WEST SUSSEX COUNTY COUNCIL CONSULTATION

TO:	Arun District Council FAO:David Easton
FROM:	WSCC - Highways Authority
DATE:	24 November 2021
LOCATION:	Land South of Summer Lane and West of Pagham Road Pagham
SUBJECT:	P/153/21/RES Approval of reserved matters (appearance, layout, landscaping and scale) following outline planning Permission P/140/16/OUT for the erection of 375 No dwellings, together with public open space, play space, drainage, parking and associated infrastructure, landscape, ancillary and site preparation works, with access off Pagham Road. This site may affect a Public Right of Way.
DATE OF SITE VISIT:	n/a
RECOMMENDATION:	More Information
S106 CONTRIBUTION TOTAL:	n/a

- Comments are made in respects of,
 - Site Plan, drawing number 21.003.02
 - Landscape General Arrangement Plans 1-5, drawing numbers L01 Rev A, L02 Rev A, L03 Rev A, L04 Rev A, L05 Rev A

DRAWING NUMBER: L01

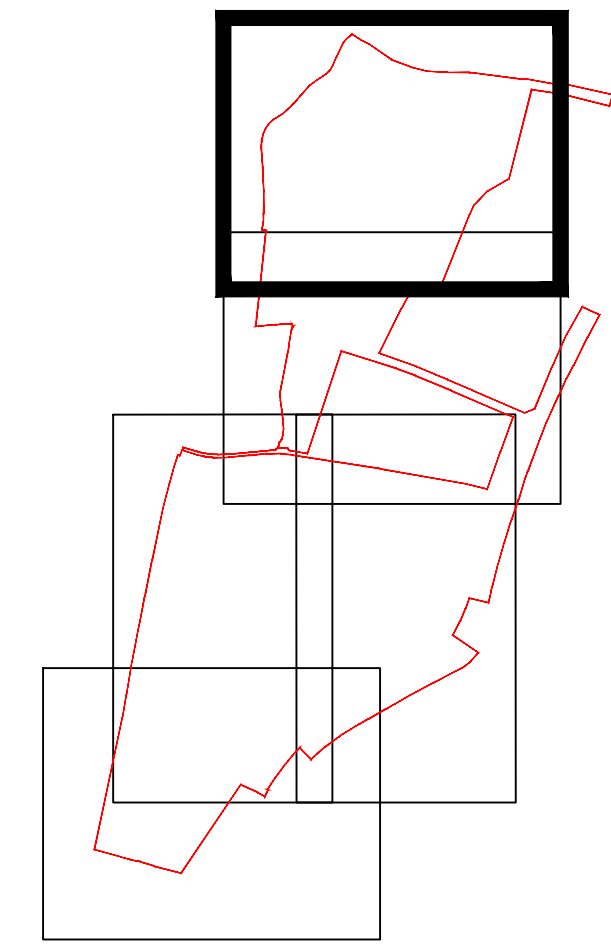
9. At all points where shared surfaces integrate with traditional segregated footway/carriageways, a length of footway should be continued into the shared surface area. This would avoid pedestrians conflicting with vehicles at junction.

10. Again, for shared surfaces, a contrasting material to that used in traditional carriageway construction must be used. Tarmac should not be used in shared surfaces. There is a large extent of shared surface within the southern phase of development that is indicated to be in tarmac rather than blockwork.

11. The use of certain materials could be rationalised. For example, it's unclear why driveways and unallocated lay-by parking spaces within traditional carriageway construction are in blockwork whereas the surrounding carriageways and footways are tarmac. In the event that roads within the site are offered for adoption, WSCC will likely seek the use of tarmac for driveways and lay-by spaces where the adjacent carriageway is also tarmac.
